**WEST SUSSEX COUNTY COUNCIL
STRATEGIC PLANNING CONSULTATION**

SUBJECT: Y/31/15/DOC - Application for approval of matters reserved by condition imposed under Y/89/14/PL relating to conditions 5, 7, 8, 9 & 10 - Construction of roads, secure cycle parking spaces, emergency access point, verification report & foul water drainage system

Land rear of Burndell Road, Yapton, BN18 0HR

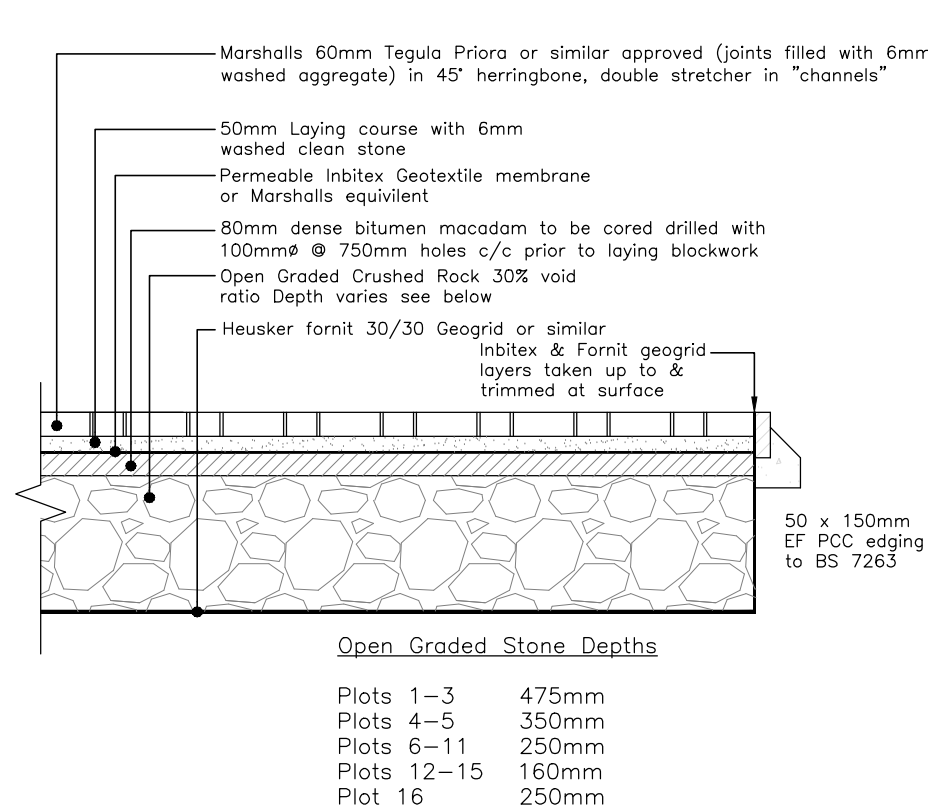
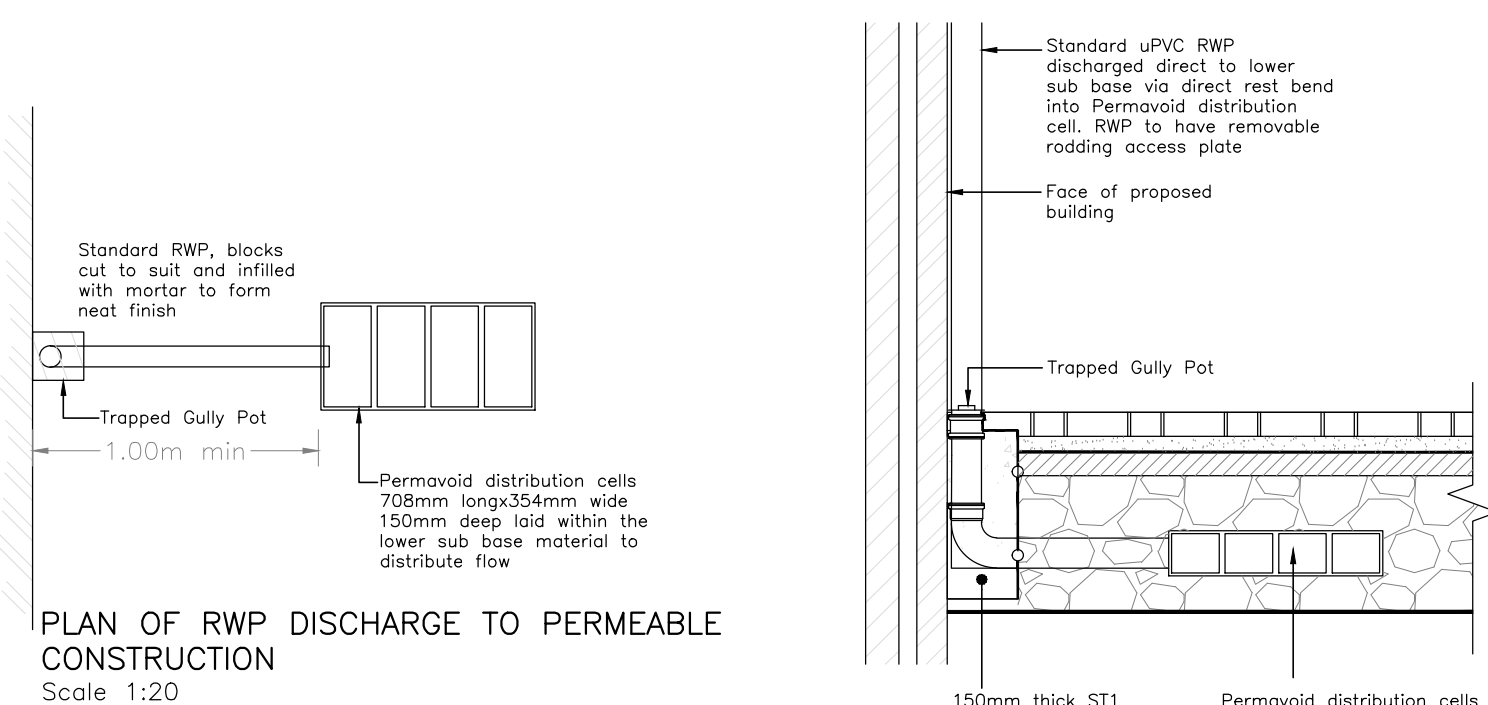
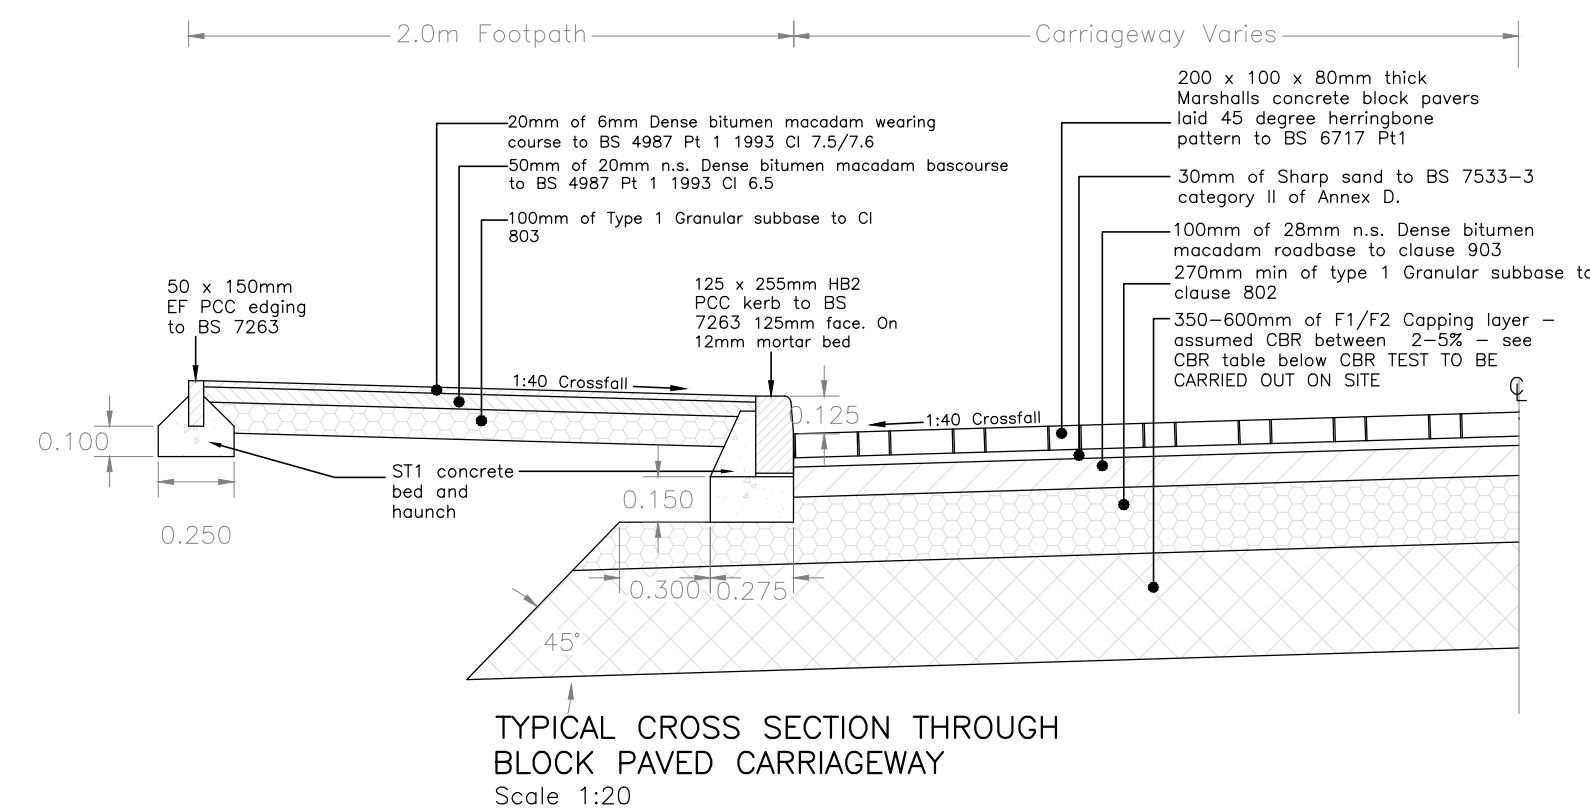
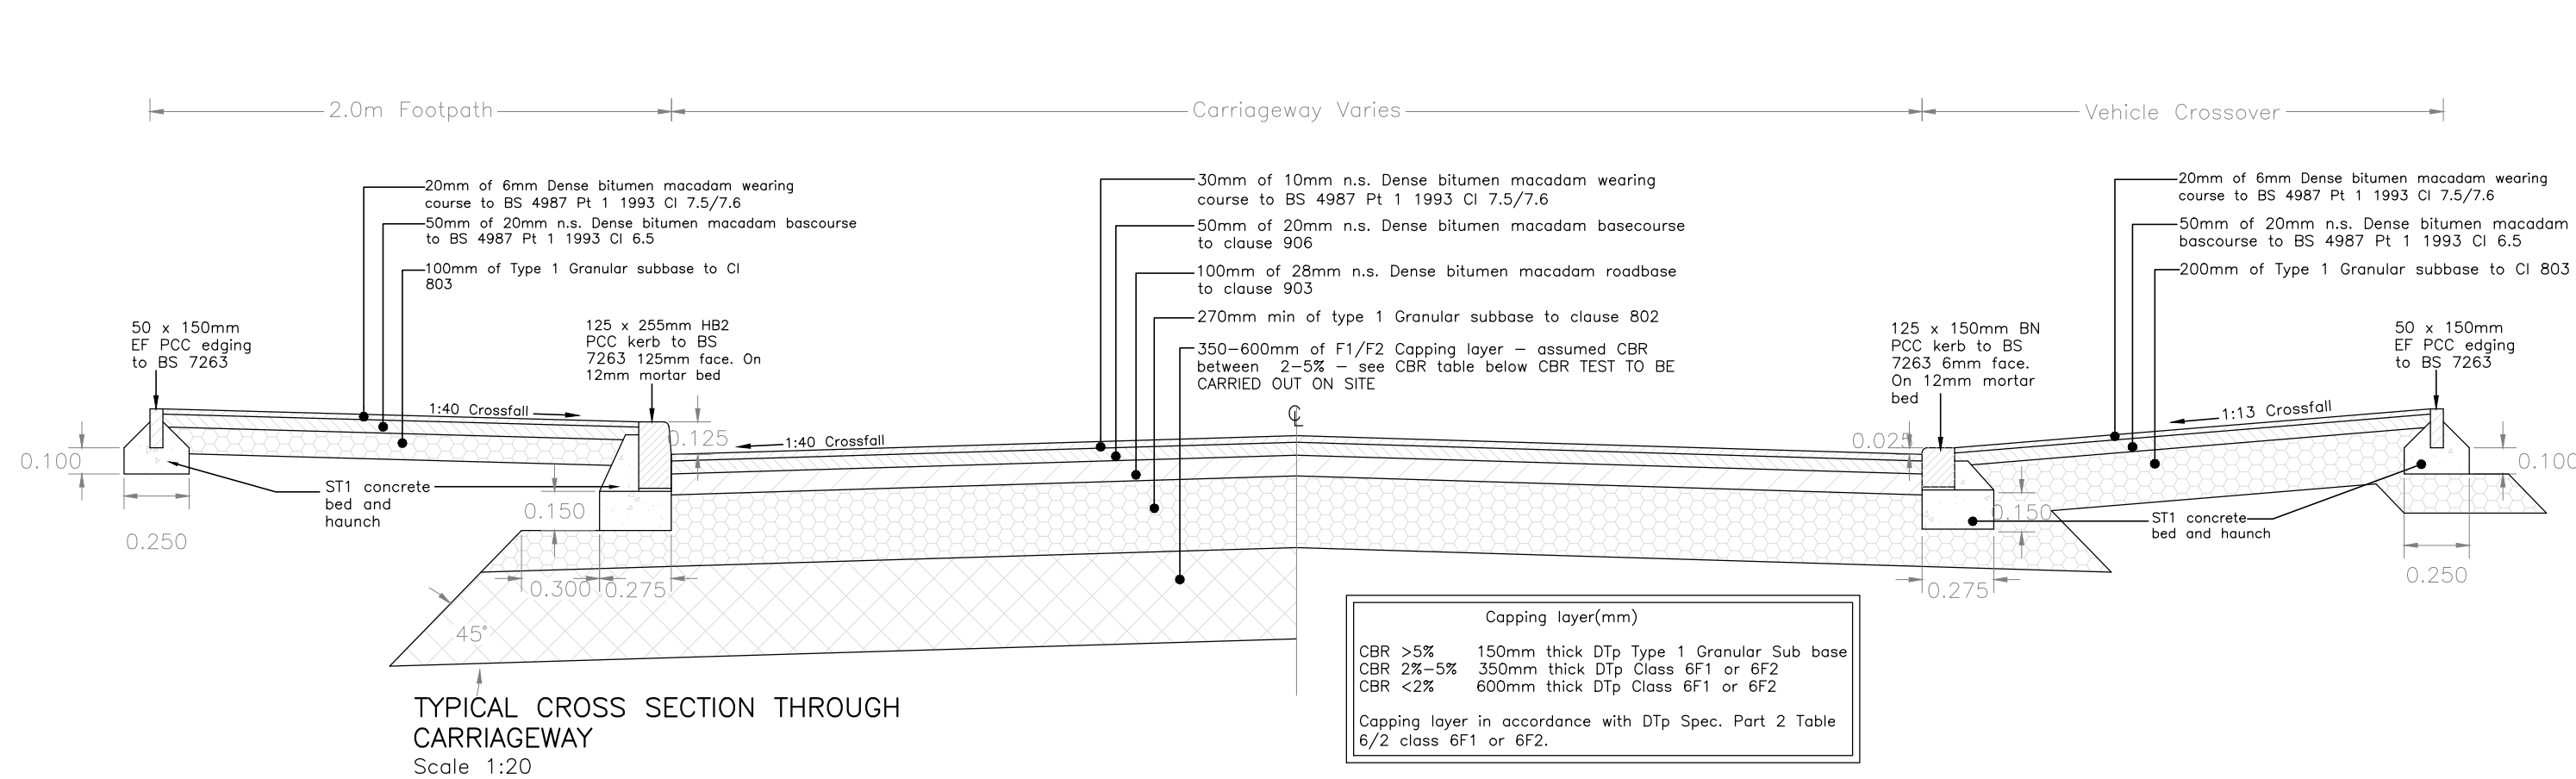
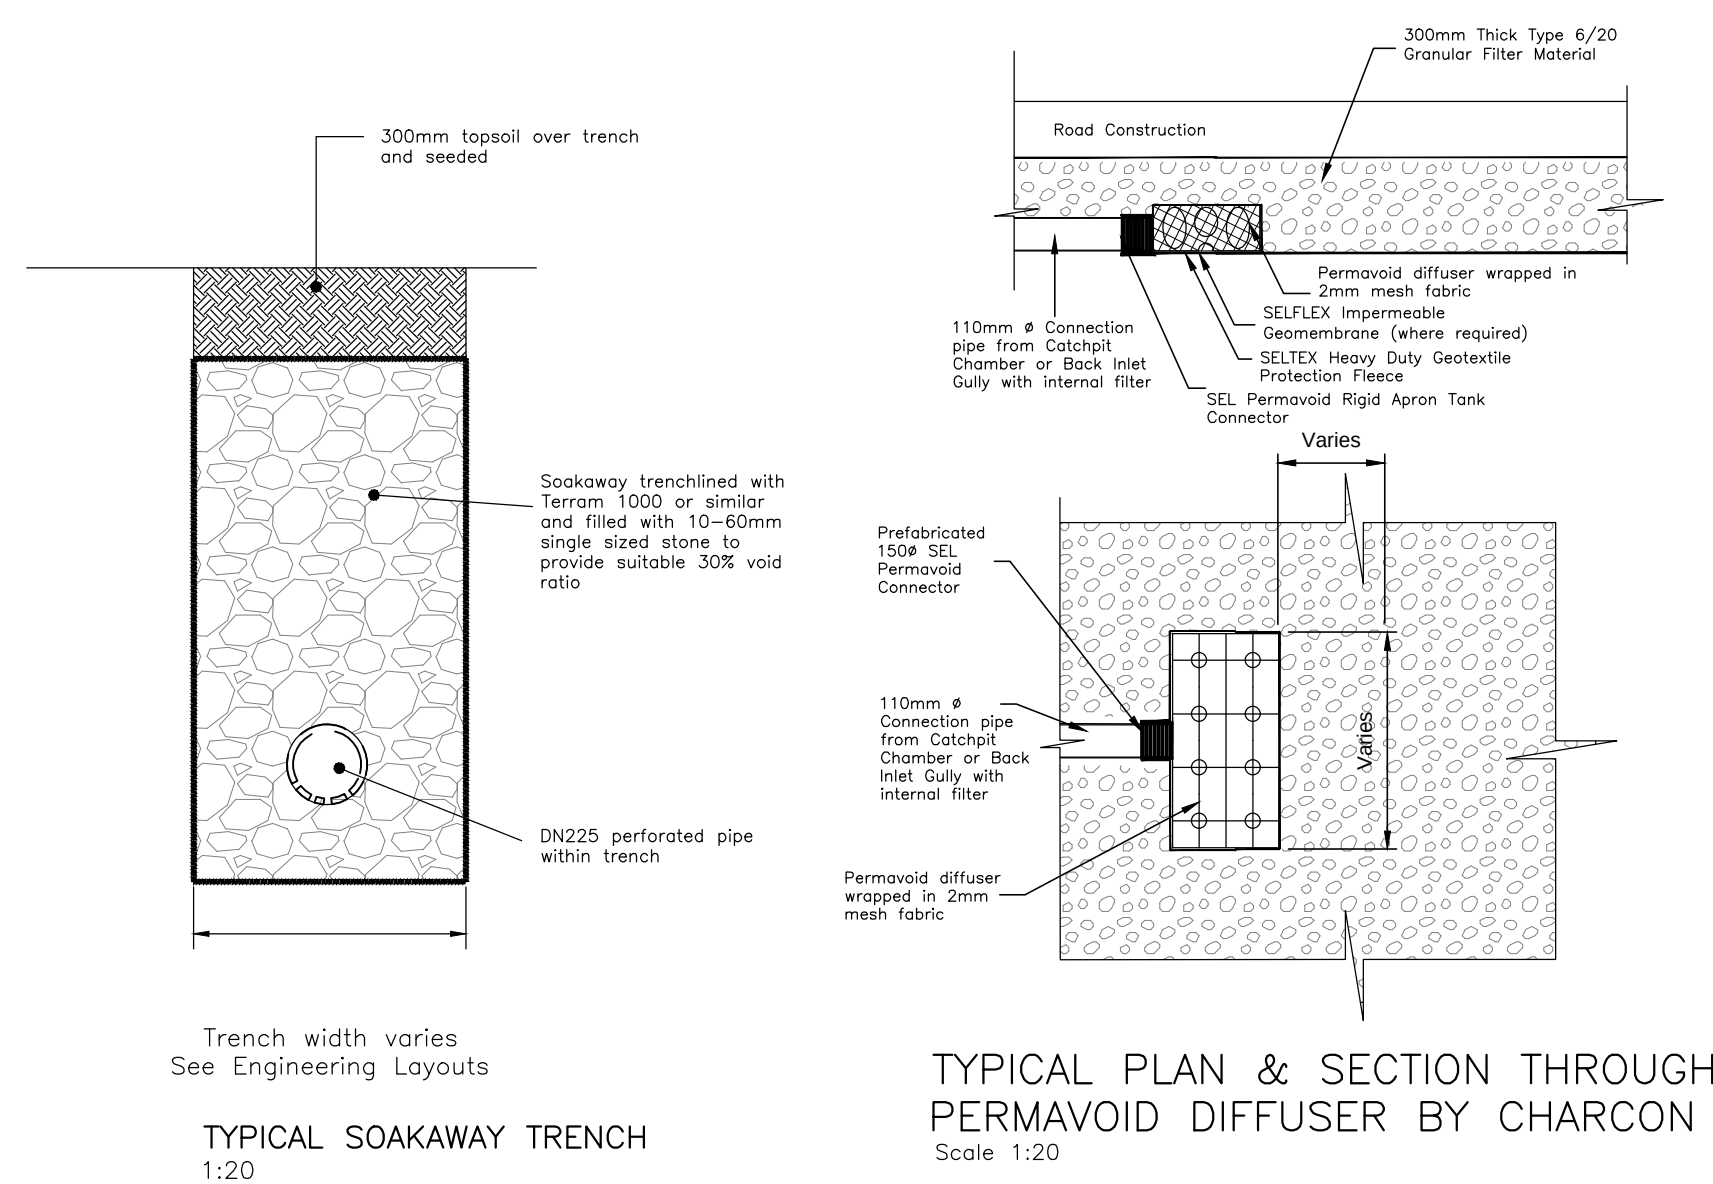
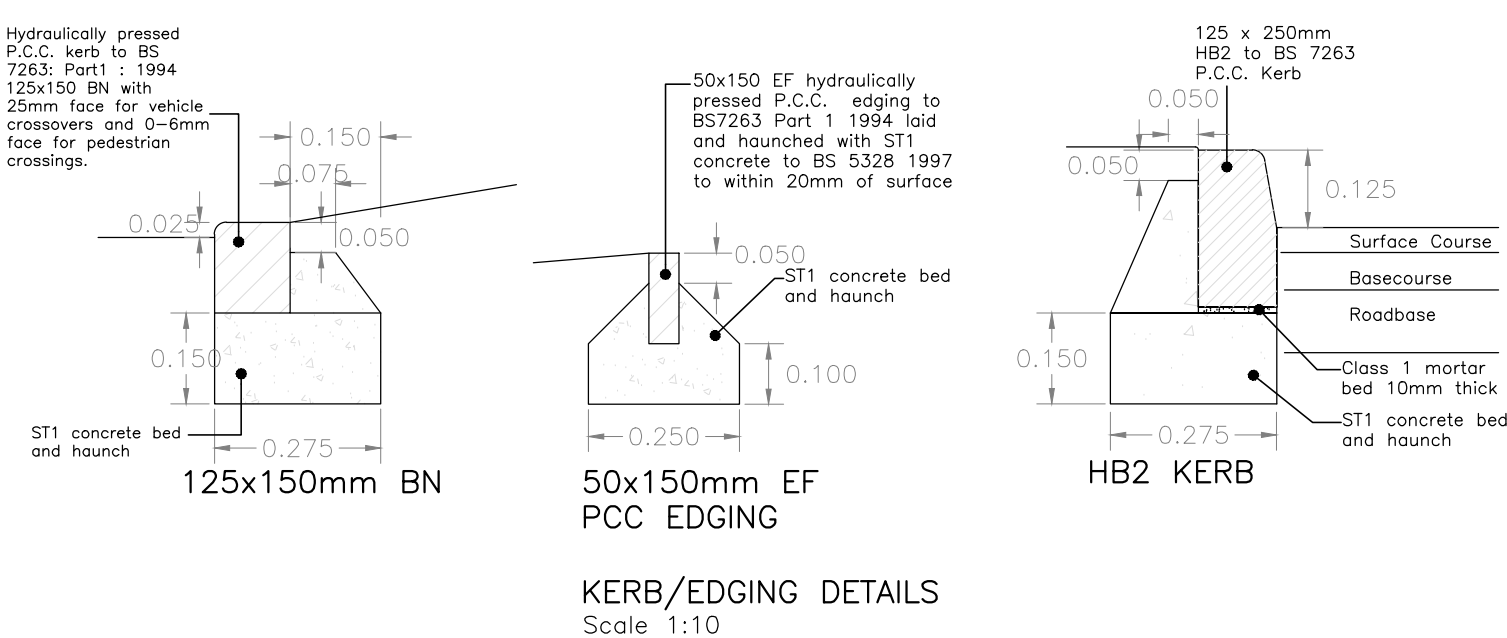
Condition 5 (construction and surfacing of roads) – Details have been provided of the surface finishes as well as typical construction cross sections. The LHA's mechanism for reviewing the acceptability of the construction is the technical approval process associated with any highway adoption agreement. According to my records, no application has been submitted to the LHA to cover the adoption of the on-site roads. It's noted also that permeable paving is proposed; the LHA do not currently adopt permeable paving. As such it would appear that the on-site roads are remaining private, the LHA would therefore not have any future maintenance responsibility for these. The LHA would not wish to comment further on these details.

BX01 5500

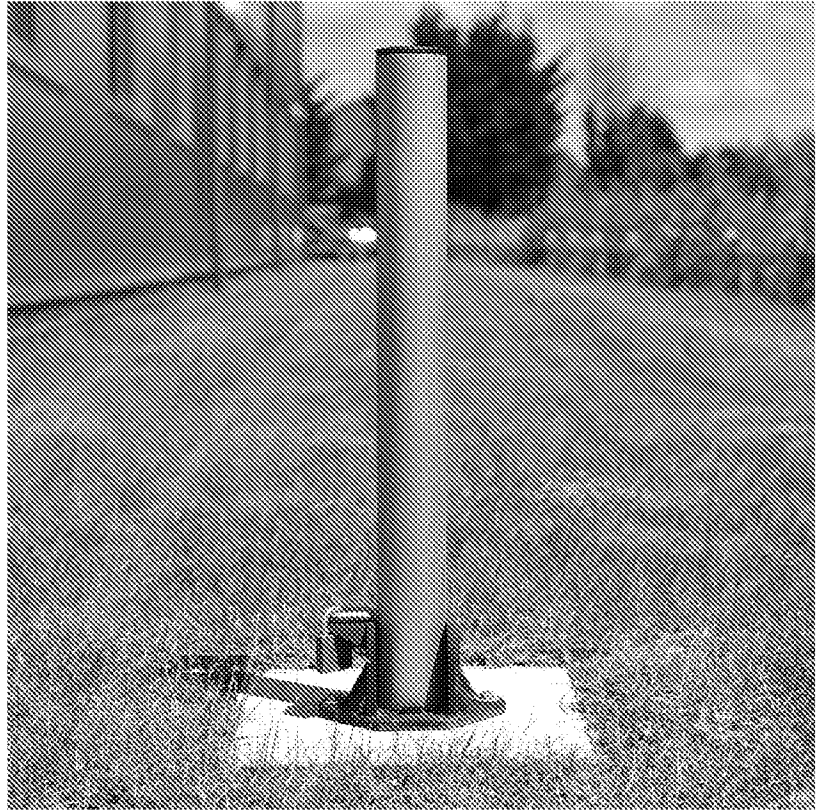
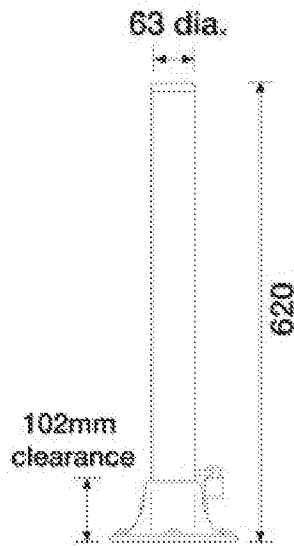
Condition 8 (emergency access) – There doesn't appear to be any particular commentary given in connection with this condition. The presumption is that the bollard details will comprise the emergency access. The details would be acceptable in preventing through traffic but can be lowered to provide emergency access. The details are acceptable, condition 8 can be discharged.
